KITTITAS COUNTY COMMUNITY DEVELOPMENT SERVICES

RE: Rosenberry Boundary Line Adjustment (BL-22-00017) – Transmittal of Comments and Request for Additional Information

Parcel# 959264	Parcel# 144835	Parcel# 634835
Parcel# 081936	Parcel# 071936	Parcel# 154835

EASEMENT V

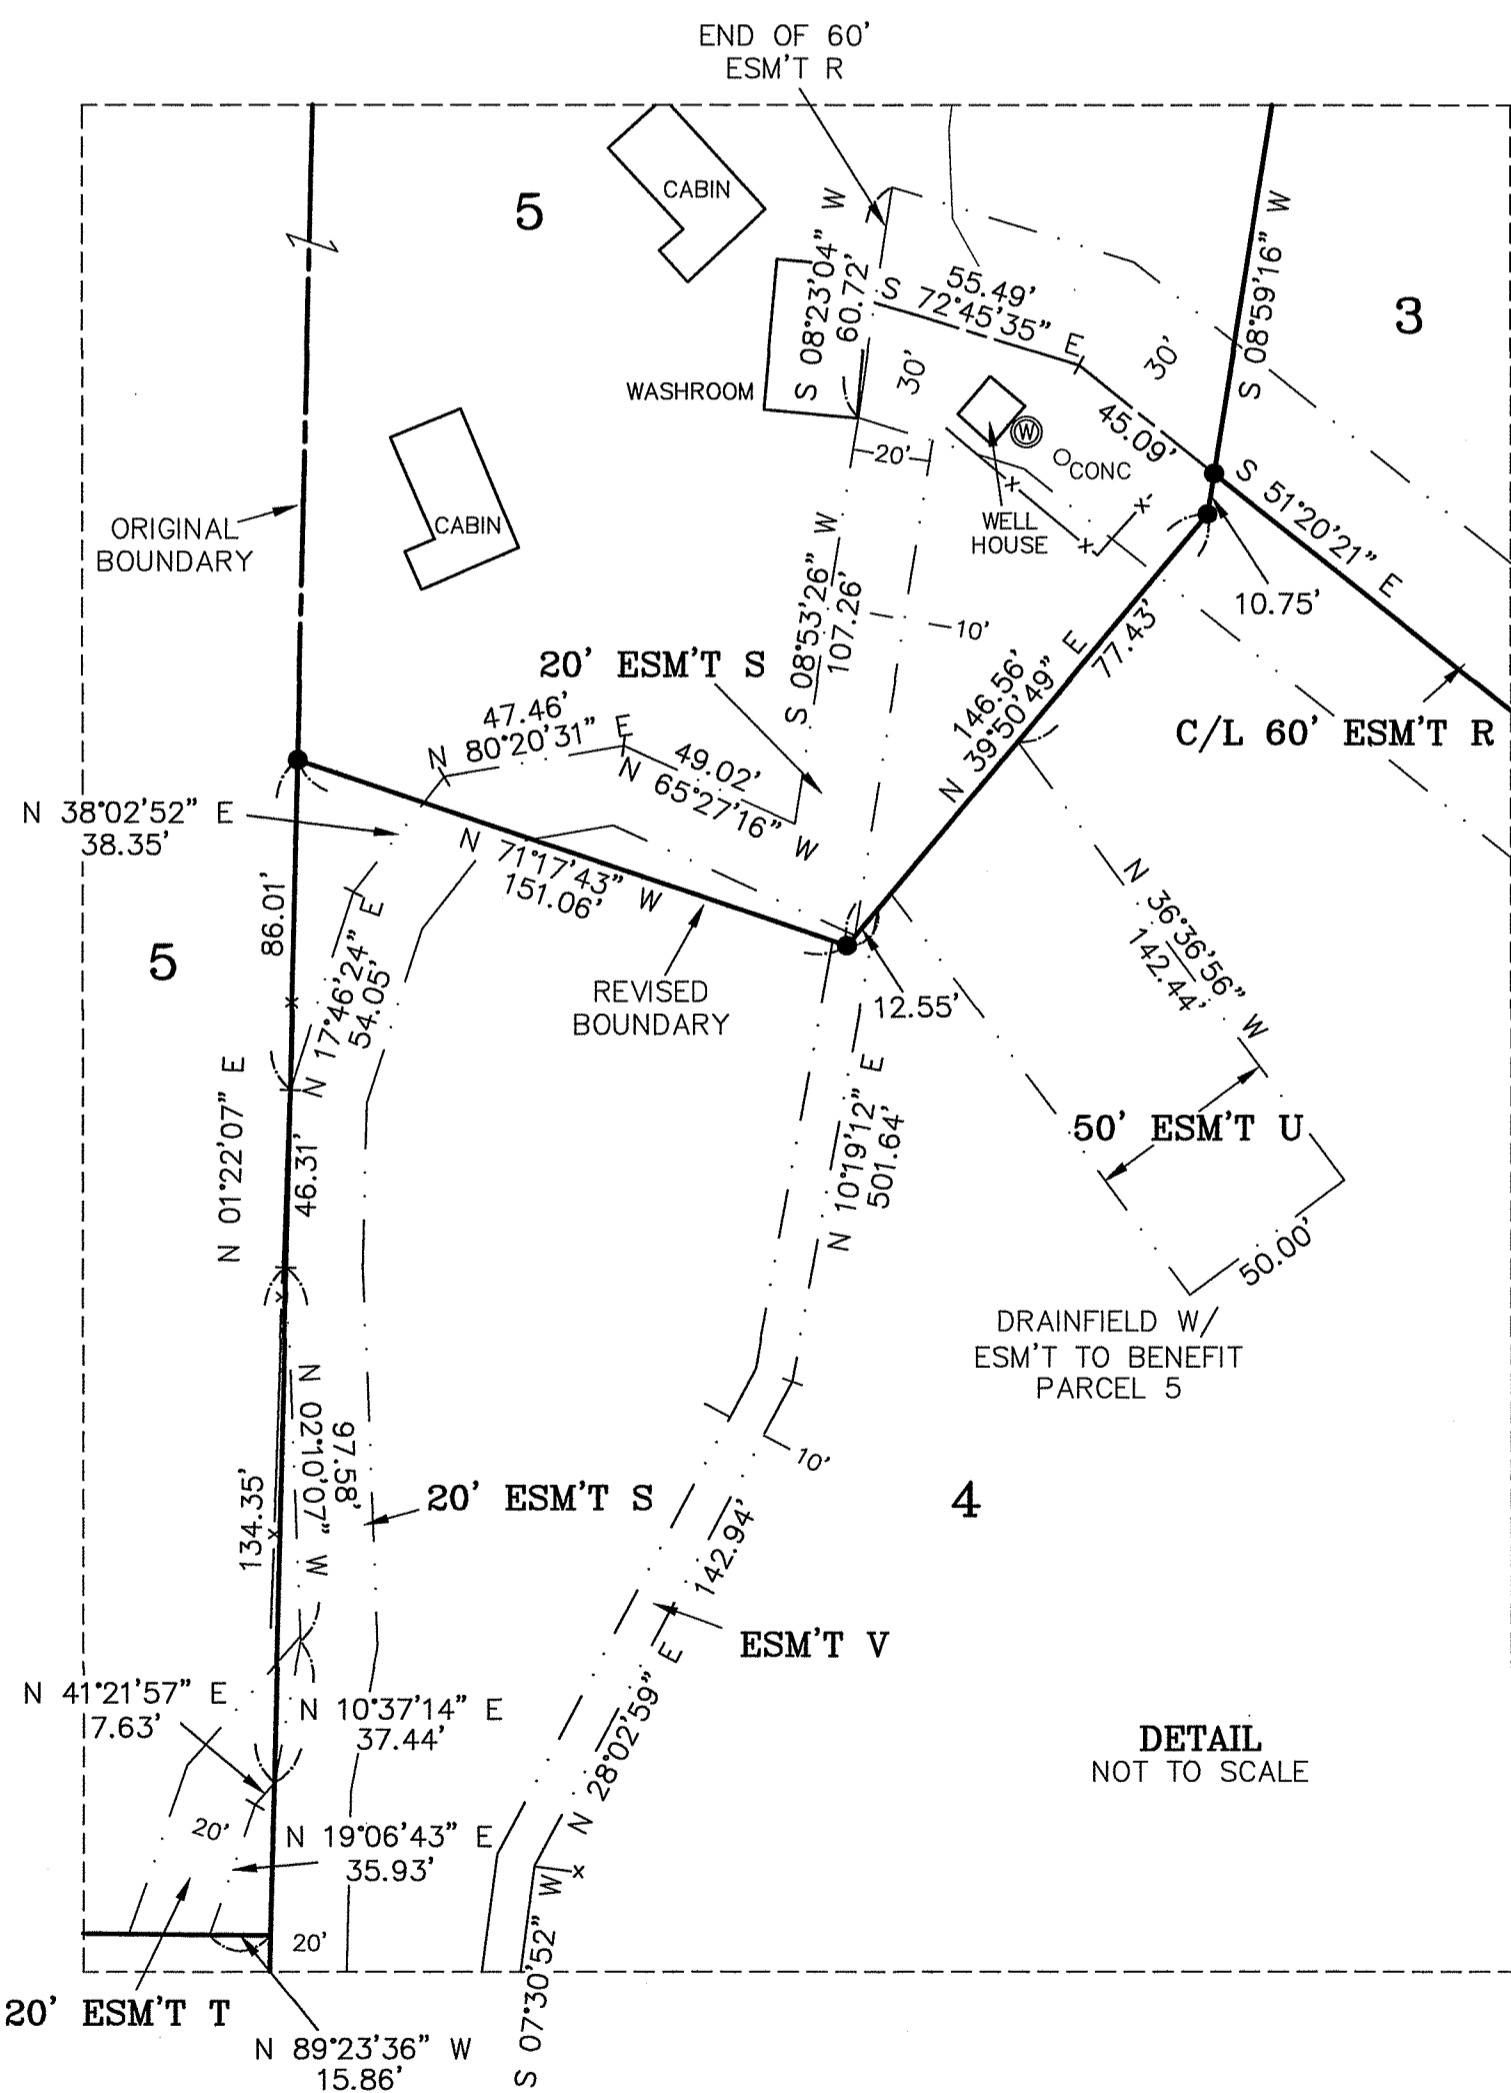
1. Provide the distance from the existing well to the property line on the new proposed property lines of parcel 5
2. Provide the distance from the septic tanks and drainfield from the proposed property line between parcel 4 and parcel 5.
3. A **preliminary survey** displaying legal descriptions, the new acreage and lot dimensions of each parcel must be submitted to our office for preliminary review (see Public Works' comments for requirement details).
4. Full year's taxes need to be paid for all tax parcel numbers per requirement of the Kittitas County Treasurer's Office. Please contact this office when this is accomplished as the Treasurer's office will not be aware of your pending application. No paperwork or receipt is required; just a phone call or an email will suffice.
5. Please refer to the enclosed comments from Kittitas County Public Works for further requirements.
